From: Amber Willard
Sent: 27 November 2019 17:09
To: [REDACTED]
Subject: Y/100/19/A

Y/100/19/A

I have been looking at the plans for the application and have some queries.

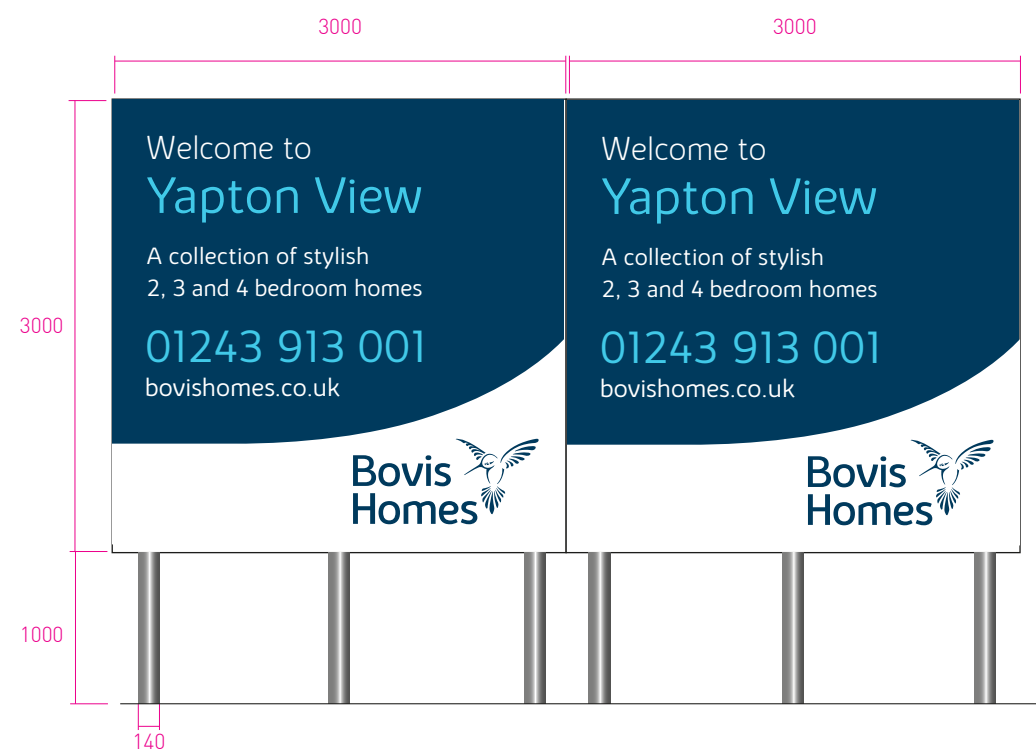
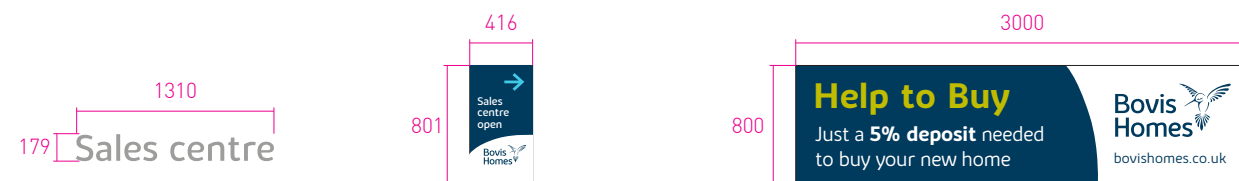
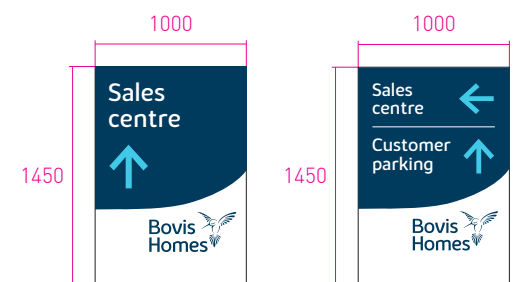
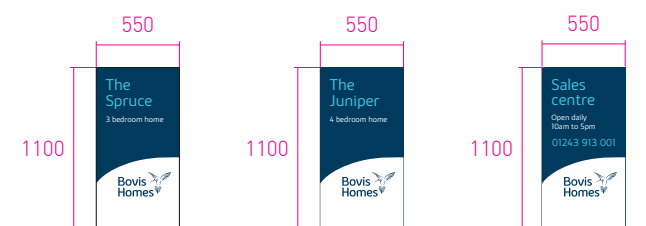
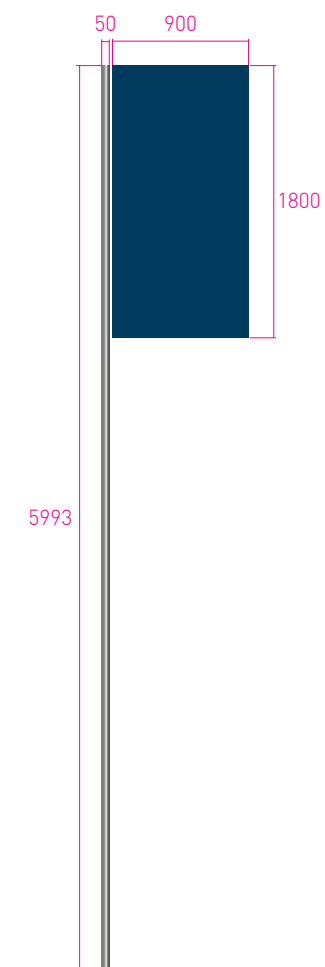
- I am unable to find K,L,O,M on the 'sales signage' Plan. Please are able to advise where they are on the plan or amend as necessary.
- The application states 2 fence panels and within the covering letter its states' two fence panels (items D and E). However on the 'sales signage' Plan, D is marked at 5 separate locations and E is marked twice. Please can you confirm if this means there will be 7 separate fence panels signs.
